**WELWYN HATFIELD BOROUGH COUNCIL
EXECUTIVE DIRECTOR - PLANNING, PUBLIC PROTECTION AND GOVERNANCE**

DELEGATED APPLICATION

Application No: 6/2022/0529/HOUSE
Location: 159 Parkway Welwyn Garden City AL8 6JA
Proposal: Construction of two rear dormers to facilitate the conversion of the loft to habitable space
Officer: Ms Emily Stainer

Recommendation: Refused

7 Proposed Rear Elevation
1 : 100

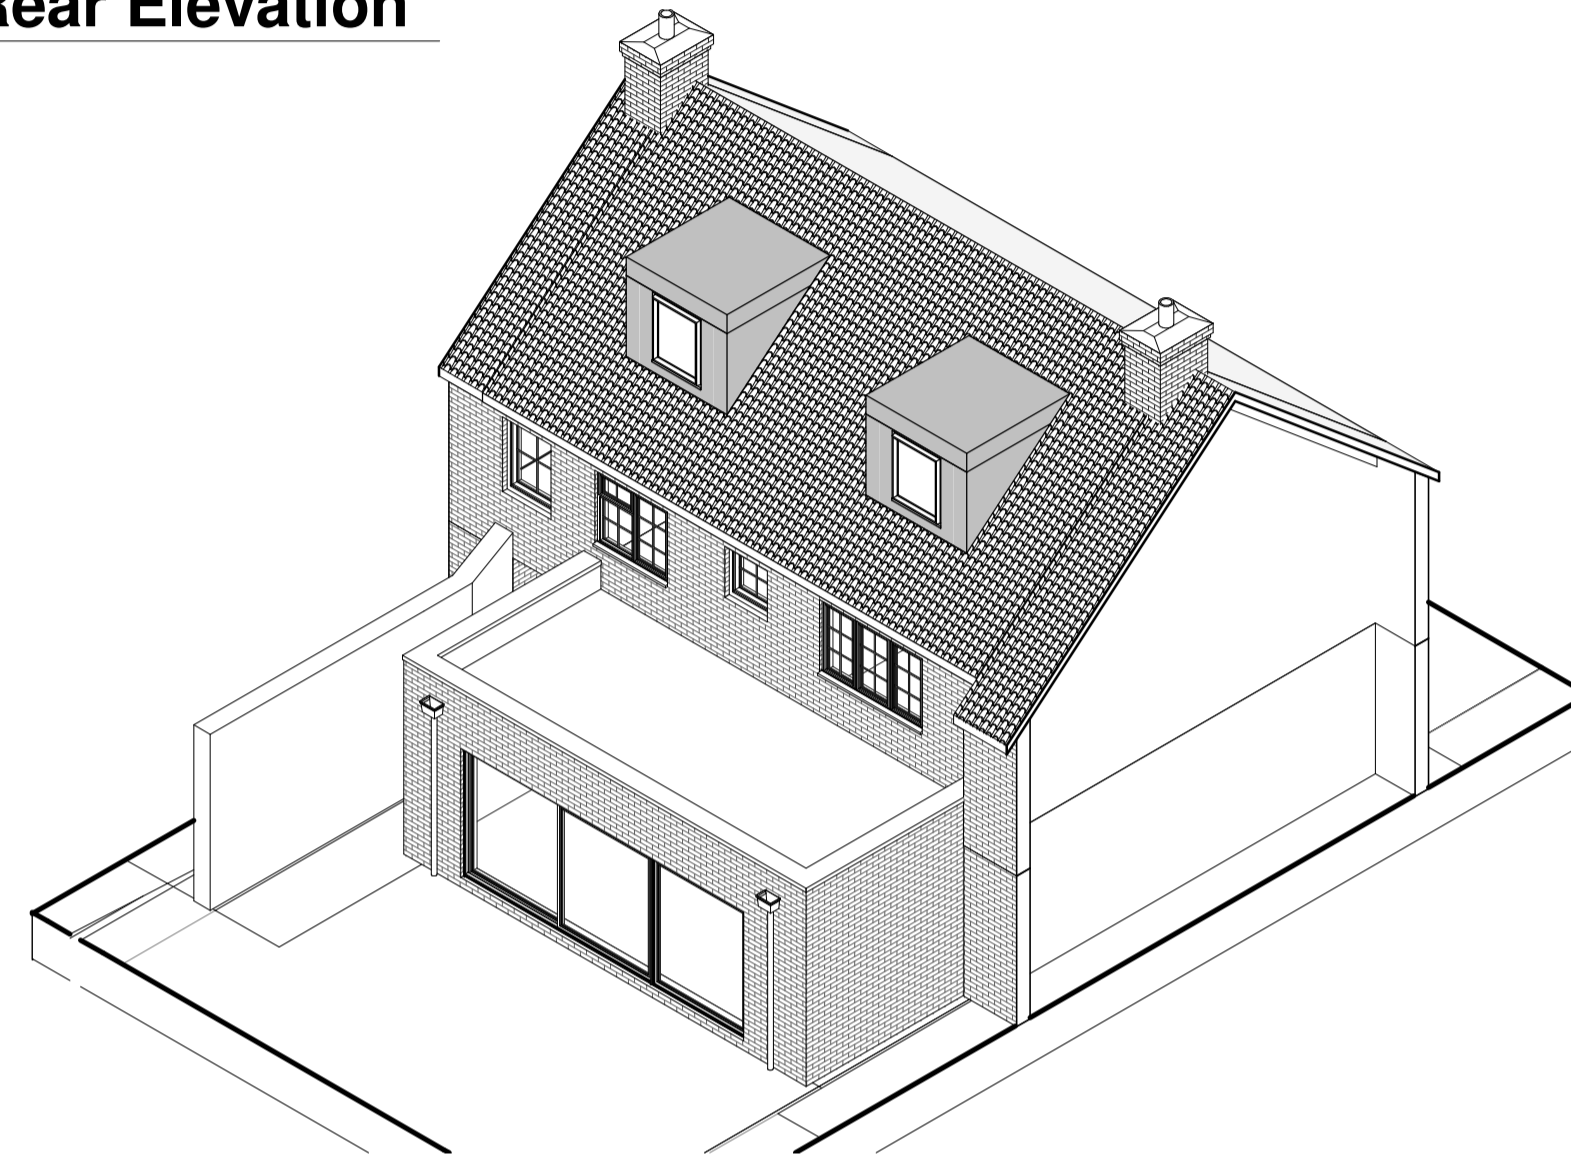
The Council's Conservation Officer has been consulted on this amended proposal and their comments reiterate that the dormers would be an incongruous feature to the terrace which would not be reflective of the original design. This is because the proposed rear dormers would be partially visible from public vantage points on Stanborough Close and Rooks Hill, which detract from the largely uninterrupted appearance of the roofscapes in the area. The comments set out that a lack of visibility from public areas does not equate to a lack of harm as the rear of buildings are seen from neighbouring gardens which are also within the Conservation Area.

It is also concluded that whilst the design has been somewhat improved through the removal of the previously proposed rooflights, the proposed dormers are still considered to cause 'less than substantial' harm to the significance of the Conservation Area and paragraph 202 of the NPPF should be applied. Consideration should also be given to paragraph 199 which affords great weight to the conservation of heritage assets and Section 72 of the Planning (Listed Buildings and Conservation Areas) Act 1990 which states that special attention shall be paid to the desirability of preserving or enhancing the character or appearance of Conservation Areas.

In summary, the dormer windows would fail to preserve or enhance the character and appearance of the Welwyn Garden City Conservation Area, resulting in 'less than substantial' harm. No public benefits have been

1. The proposed dormers would fail to preserve or enhance the character and appearance of this part of the Garden City and would harm the significance of the Conservation Area. Accordingly, the proposed development is contrary to the provisions of Section 72 of the Planning (Listed Buildings and Conservation Areas) Act 1990, Policies D1 and D2 of the District Plan 2005, the Welwyn Hatfield Supplementary Design Guidance 2005, Policies SP9 and SADM15 of the Welwyn Hatfield Draft Local Plan 2016 and the National Planning Policy Framework.
